Dyddiad/Date: 14 January 2025

**FFERM WYNT ALLTRAETH MONA / PROPOSED MONA OFFSHORE WINDFARM
CYFEIRNOD YR AROLYGIAETH GYNLLUNIO / PLANNING INSPECTORATE
REFERECE: EN010137**

**RE: NATURAL RESOURCES WALES' DEADLINE 7 SUBMISSION AND CLOSING
STATEMENT**

Figure 1.1: Spatial partitioning between northern gannet breeding colonies in the breeding season. Grassholm is indicated on the figure (source: Wakefield *et al.* (2013))

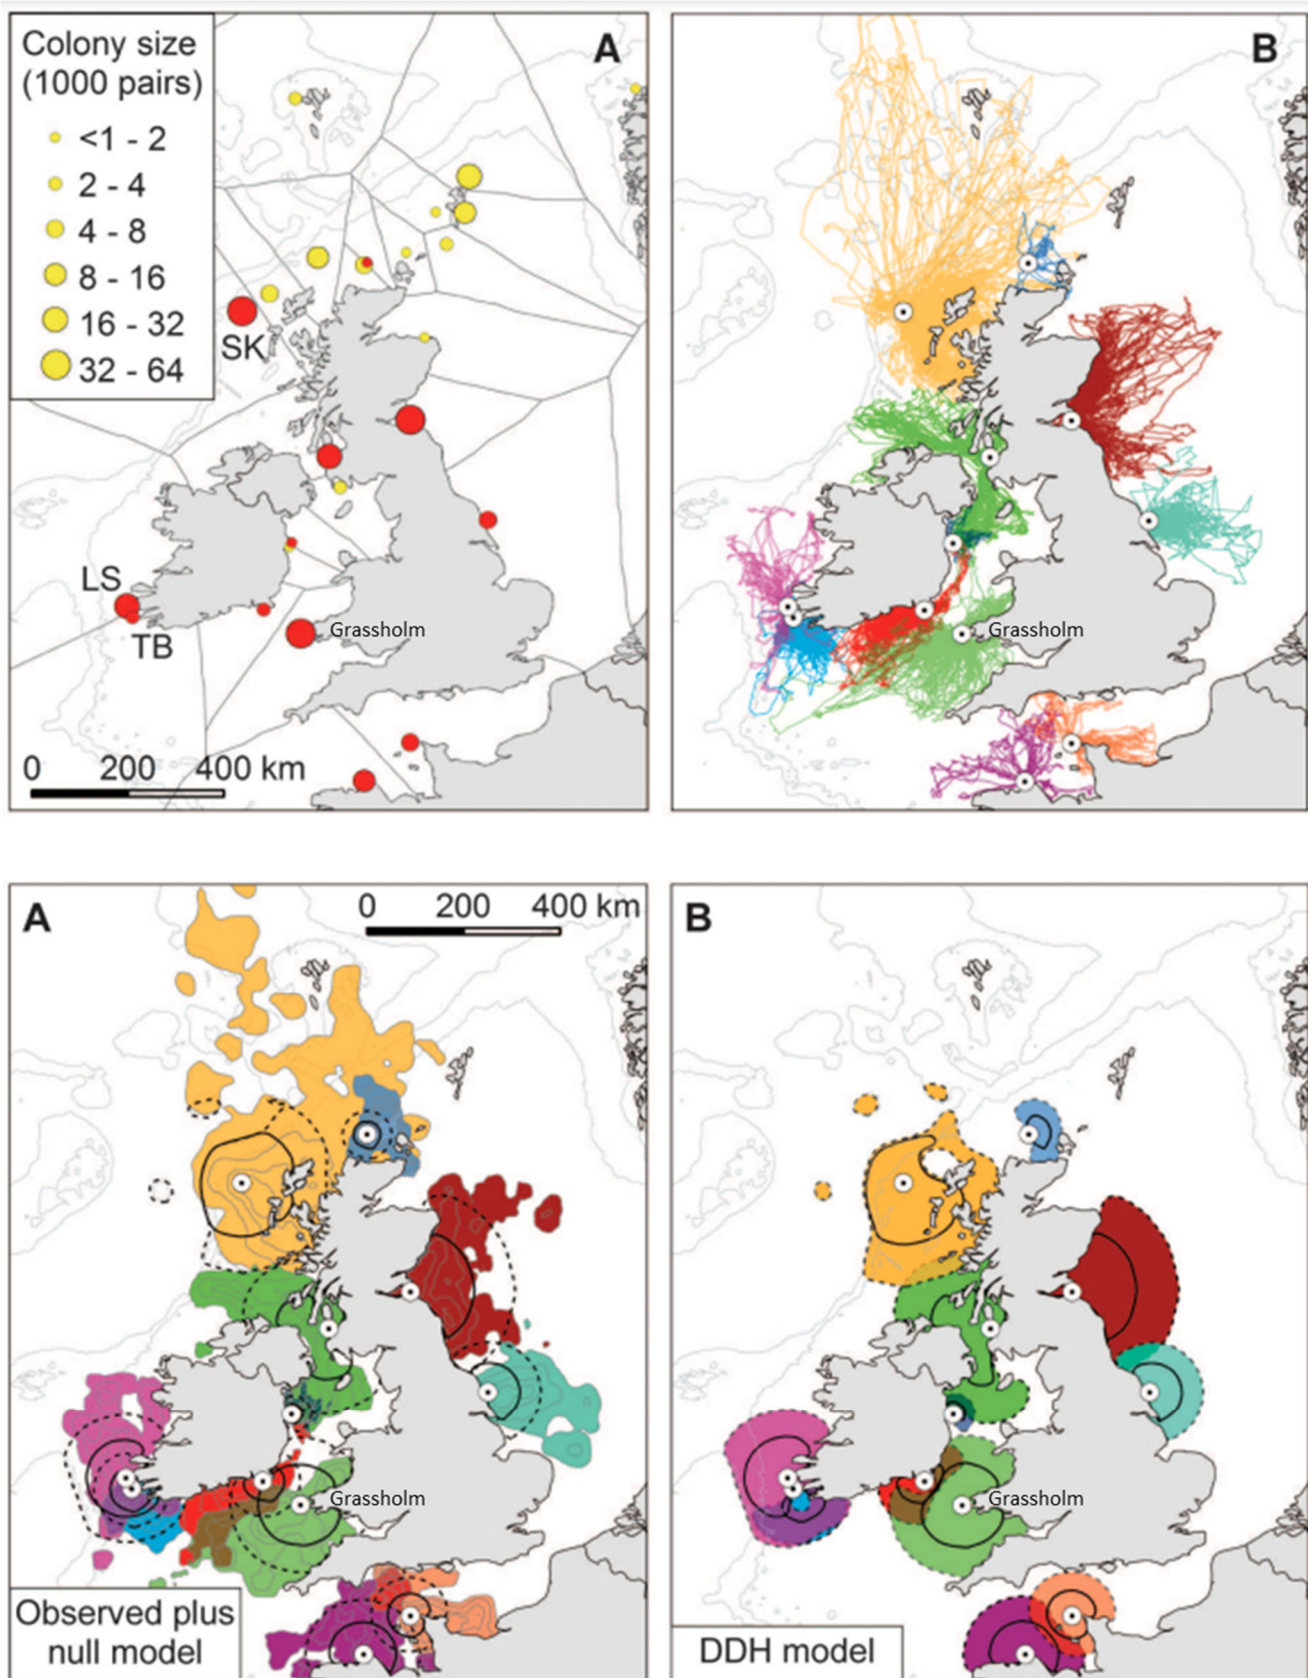
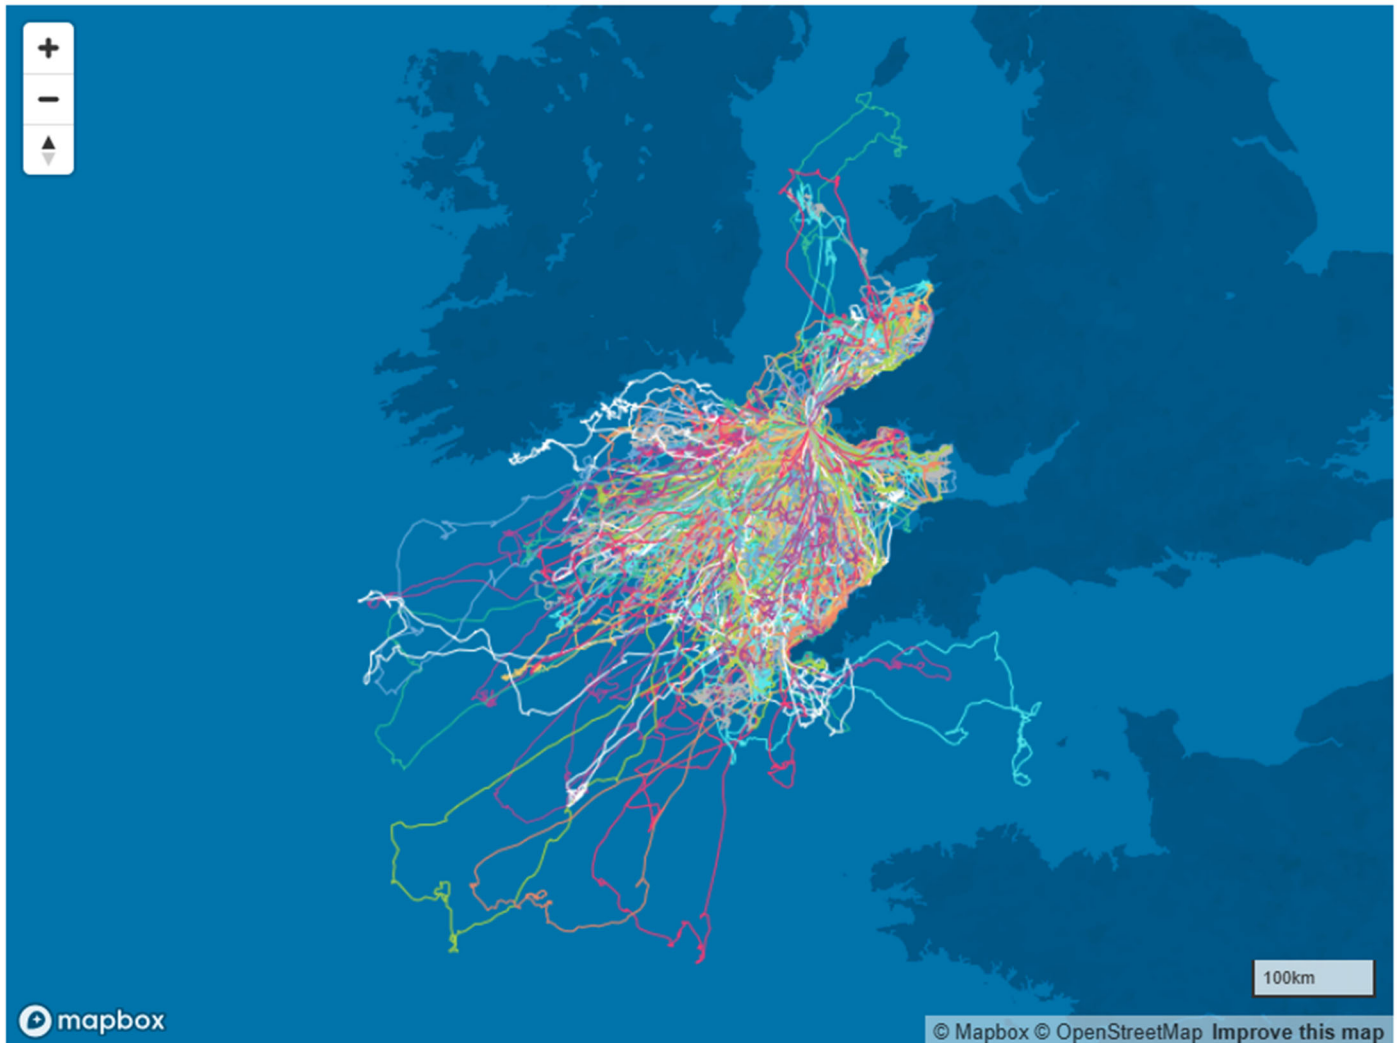
- As we noted in our Deadline 6 response [REP6-137], tracking data (e.g. from Votier et al. 2010) and utilisation distributions (e.g. Wakefield et al. 2013) suggest that gannets have been shown to display spatial segregation between colonies and that it is unlikely that gannets from Grassholm SPA will forage in the North Irish Sea/Liverpool Bay area. This is shown by the Applicant in Figures 1.1 and 1.2 of REP6-088. Therefore, we consider that the breeding season apportionment values calculated by the Applicant for the wind farms located in the Liverpool Bay/North Irish Sea - and hence the apportioned in-combination collision, displacement and therefore combined collision plus displacement impacts to the colony in their assessment - are overly precautionary. We welcome that this is acknowledged by the Applicant in paragraph 1.5.1.4 of REP6-088.

Figure 1.3: PVA output graph for northern gannet from Grassholm SPA (dashed lines represent the 95% LCI and UCI)

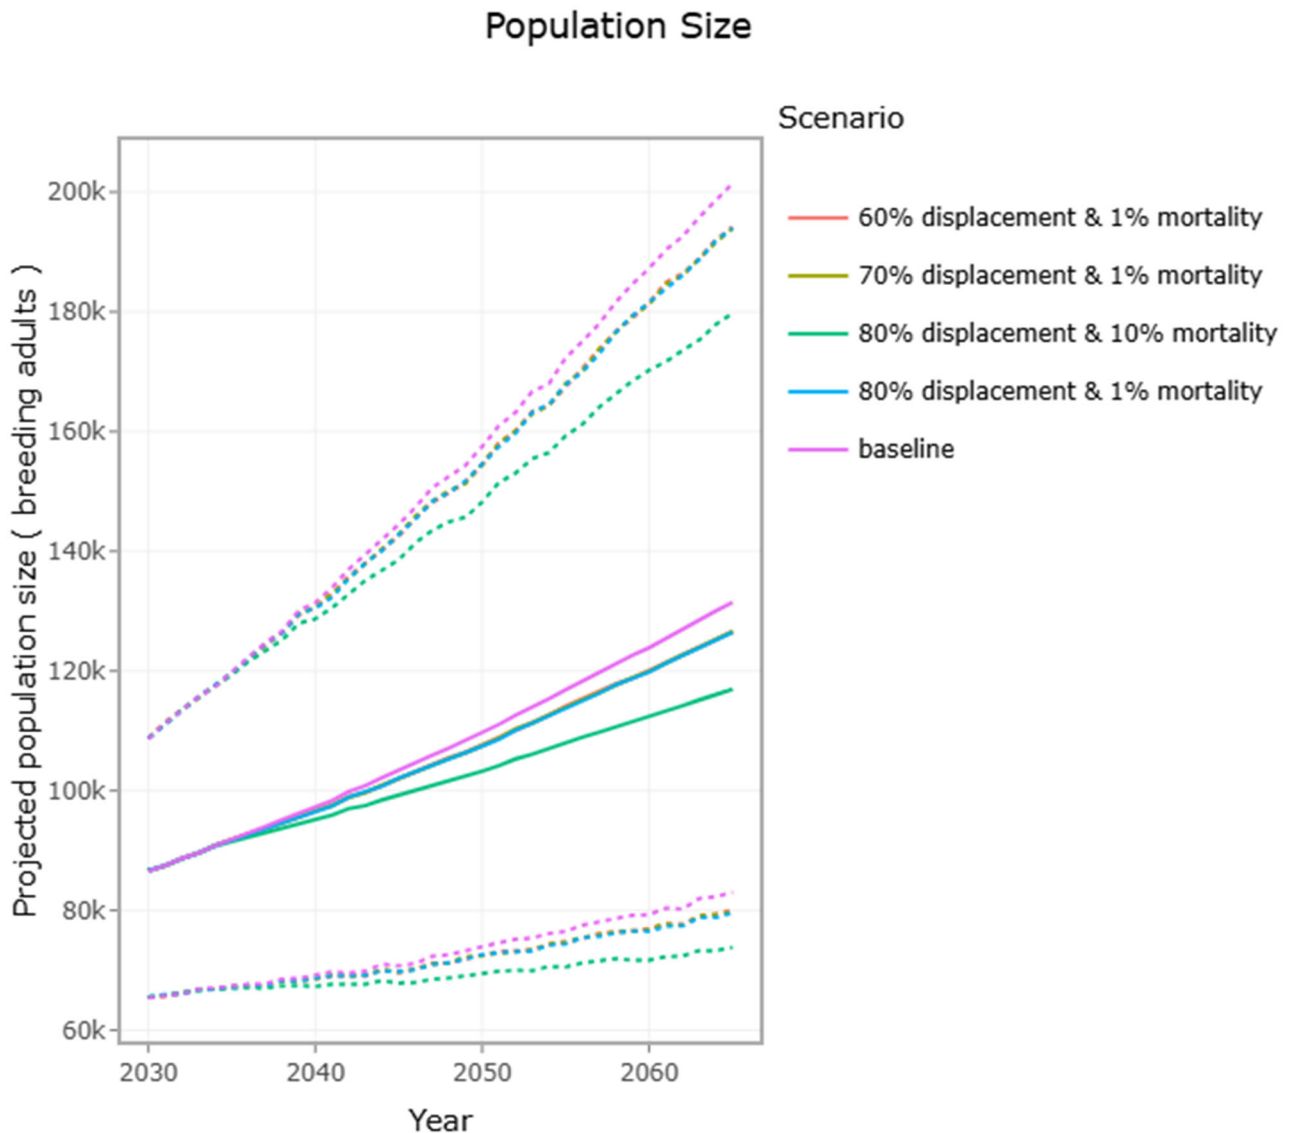
7. The results from the Applicant's Population Viability Analysis (PVA) for this worst case scenario (no macro avoidance, 80% displacement and 10% mortality) suggest that for an impact of 231 adult gannets per annum from the SPA, the population of the SPA will be able to continue growing even with the additional impact from the offshore wind farms (OWFs), as indicated by a growth rate above 1, and the Counterfactual of Growth Rate of 0.996 (see Table 1-13 of REP6-088). This suggests that even at this extreme worst-case scenario of 80% displacement and 10% mortality plus collisions, there will be only a small impact on the growth rate in comparison to baseline conditions.
